## Engineers Comments Regarding Surface Water Drainage

| <b>Application Reference:</b>   | WA/86/25/DOC                                                                                                                                                                                                                                | <b>Reviewer Reference:</b> | ADC/EXT5/AF |
| <b>Site Name:</b>               | Barnfield House Arundel Road Walberton BN18 0SD                                                                                                                                                                                             |                            |             |
| <b>Application Description:</b> | Approval of details reserved by condition imposed under reference WA/58/23/S73 relating to condition 9 - as-built drawings of surface water drainage scheme (see WA/85/25/DOC for conditions 12 - cycle parking and 18 - acoustic testing). |                            |             |

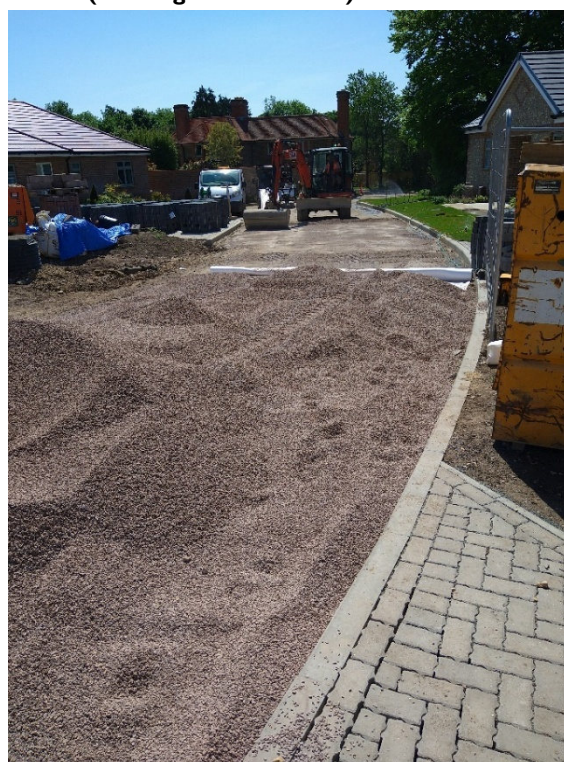
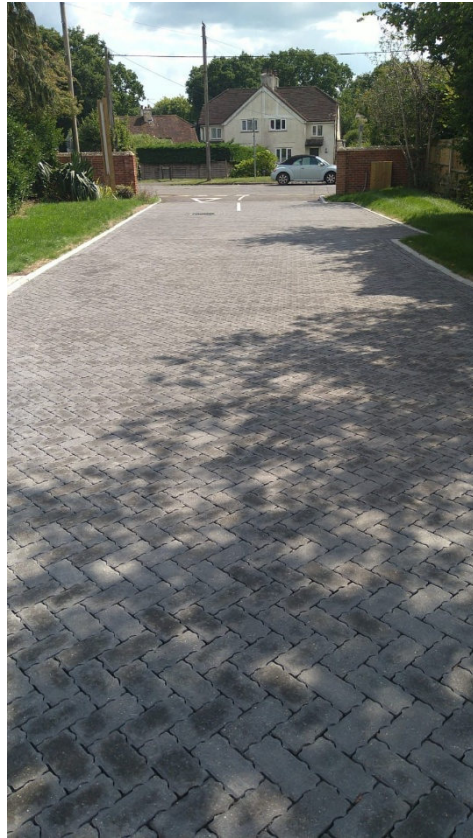
|                            | ADC Drainage Comments                                                                                                                                                                                                                                                                                                                                                                                                                                                      | Designer Response                                                                                            | ADC Drainage Comments                                                                                                                                                                                                                                                                                                                                                                 | ADC Drainage Comments                                                                                                                                      |  |
|----------------------------|----------------------------------------------------------------------------------------------------------------------------------------------------------------------------------------------------------------------------------------------------------------------------------------------------------------------------------------------------------------------------------------------------------------------------------------------------------------------------|--------------------------------------------------------------------------------------------------------------|---------------------------------------------------------------------------------------------------------------------------------------------------------------------------------------------------------------------------------------------------------------------------------------------------------------------------------------------------------------------------------------|------------------------------------------------------------------------------------------------------------------------------------------------------------|--|
| 1.                         | <p>Photographic evidence should be provided for each permavoid storage and concrete dam installation, with references marked on the plans.</p> <p>ADC Drainage Comments (10/12/2025)<br/>The six permavoid installations are photographed and appear to be the correct size. We cannot confirm from the additional photos provided whether the concrete baffles are all installed. The baffle weep holes between compartments which act as flow controls are currently</p> | <p>Photographs have now been provided in the updated report of the concrete baffles with the weep holes.</p> | <p>There are five dams all with different and specific weep hole diameters (ranging from 35-100mm diameter) which act as flow control devices for the compartments. The photographs provided do not evidence the sizes or locations and appear to show multiple pipes through individual baffles which would increase the flow to the lower compartment and may lead to flooding.</p> | <p>Drainage Verification Report rev P4 provides the required information and confirms appropriate remedial works have been undertaken. Comment closed.</p> |  |

Fig 8. Orifice Drain

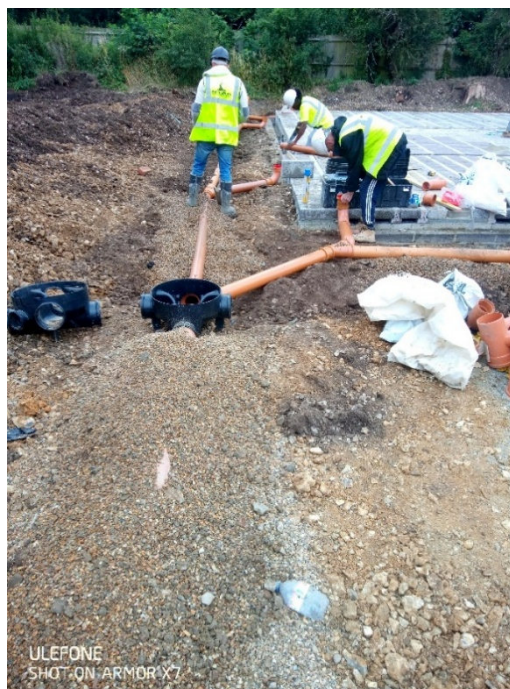
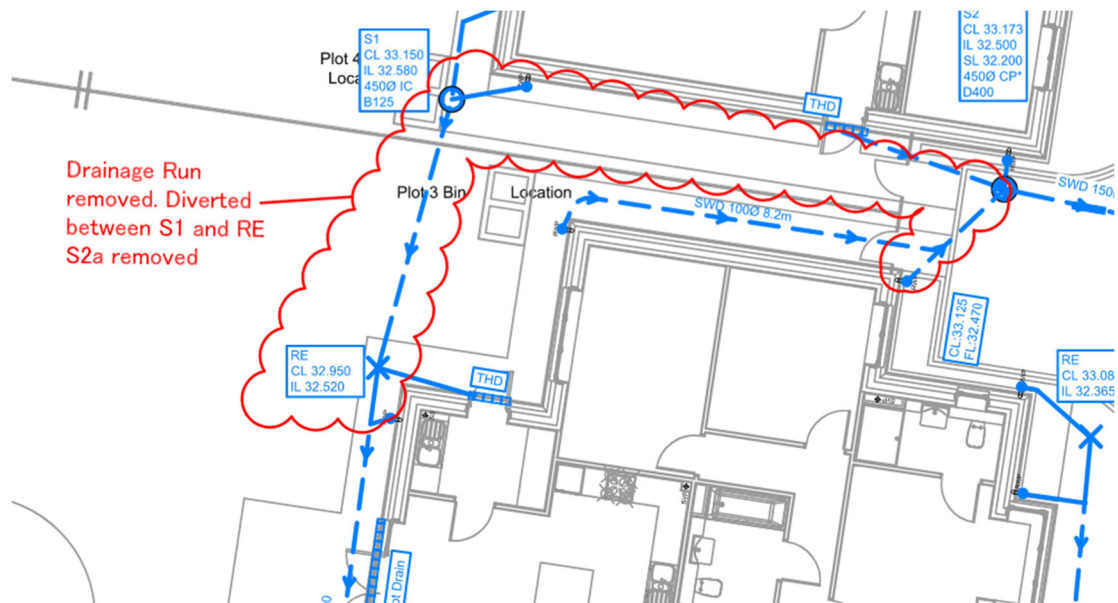
| 3. | <p>Evidence of all flow control chambers – product, orifice diameter, IL plus photos of internal chamber as installed</p> <p>ADC Drainage Comments (10/12/2025)<br/>Evidence of all flow control chambers - product, orifice diameter, IL plus photos of internal chamber as installed. There is no photograph of S14 installed. The orifice diameters for the flow control chamber is not evidenced for S14 or S18.</p> | <p>Photographs have now been provided in the updated report of the orifice chambers. The product is confirmed as the SEL 500 diameter flow control chamber and the invert levels as designed.</p>                              | <p>The chamber type is not sufficient. The flow control device orifice size is crucial to the correct functioning of the system</p> | <p>Drainage Verification Report rev P4 provides the required information. Comment closed.</p>                   |  |
